WEST SUSSEX COUNTY COUNCIL CONSULTATION

TO:	Arun District Council FAO: Anita Gardner
FROM:	WSCC - Highways Authority
DATE:	22nd September 2020
LOCATION:	Land North of Mayflower Way Angmering BN16 4AY
SUBJECT:	A/136/20/PL Erection of 24 No. dwellings with garaging & open residential & visitor parking, new access from Mayflower Way, provision of hard & soft landscaping & open space, foul & surface water drainage systems & other works (resubmission following A/46/20/PL). This application is Liable as 20 new dwellings in CIL Zone 2.
DATE OF SITE VISIT:	n/a
RECOMMENDATION:	Advice
S106 CONTRIBUTION TOTAL:	n/a

A Plots 1 to 4 - garages removed. AUG.20

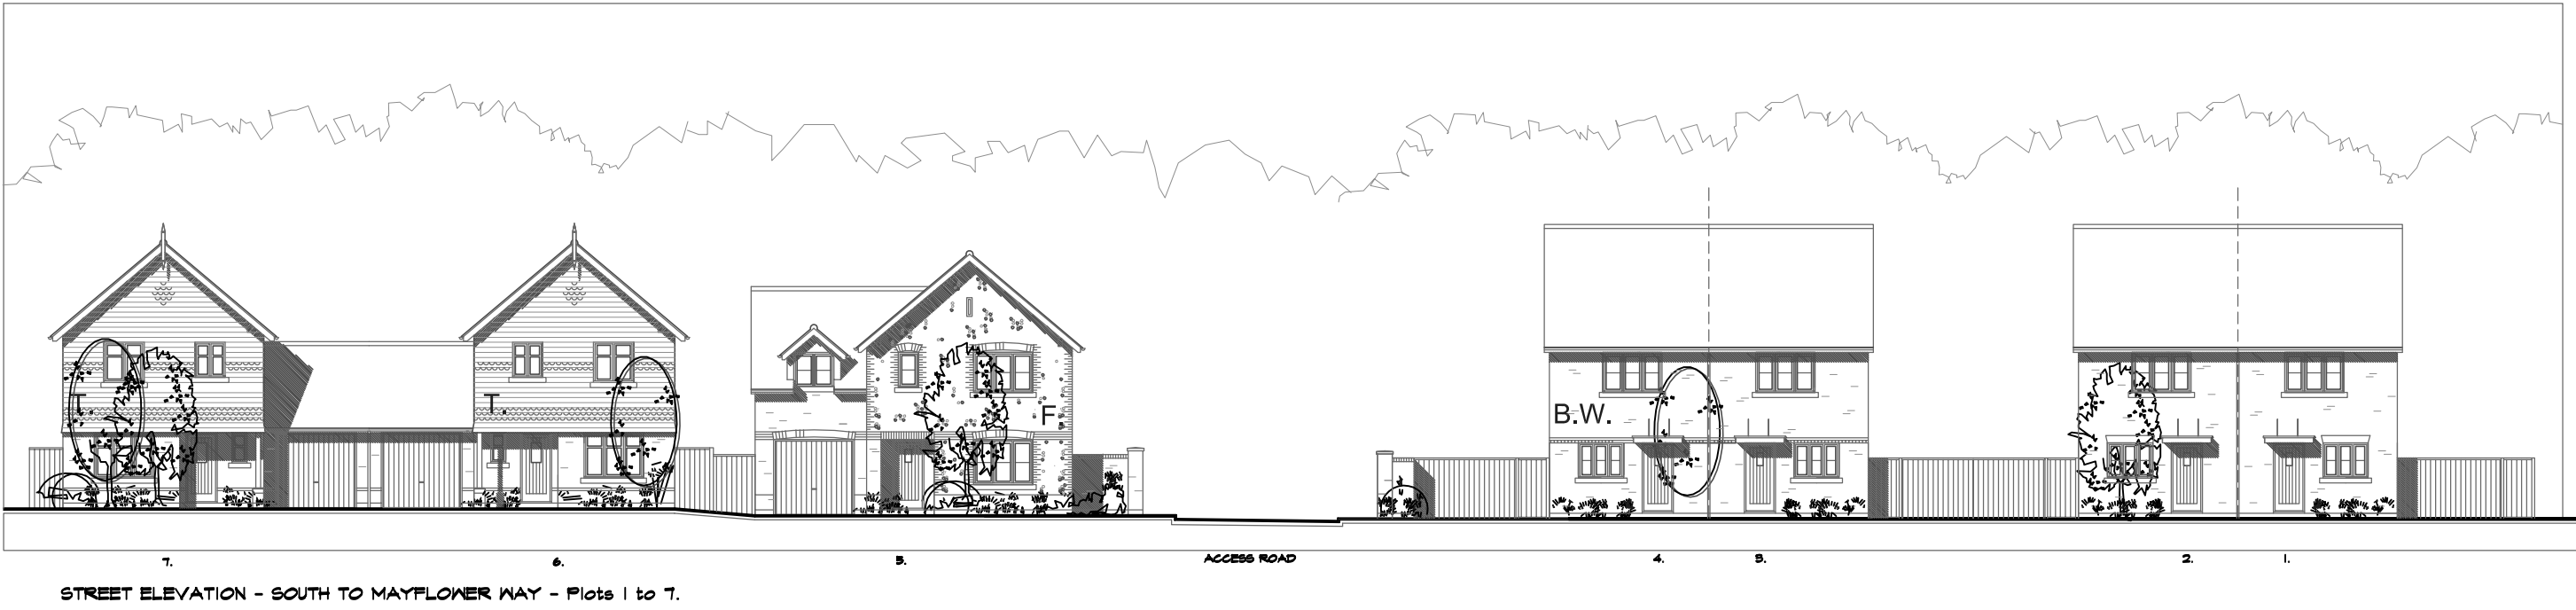
The earlier application A/46/19 was granted consent in February 2019. This application is essence proposes to adjust the parking arrangements in relation to plots 1-4 by changing from garage to driveway parking. The LHA would not raise any concerns with these minor amendments. The remaining comments made by the LHA in our consultation response from 2019 under A/46/19 would still stand.
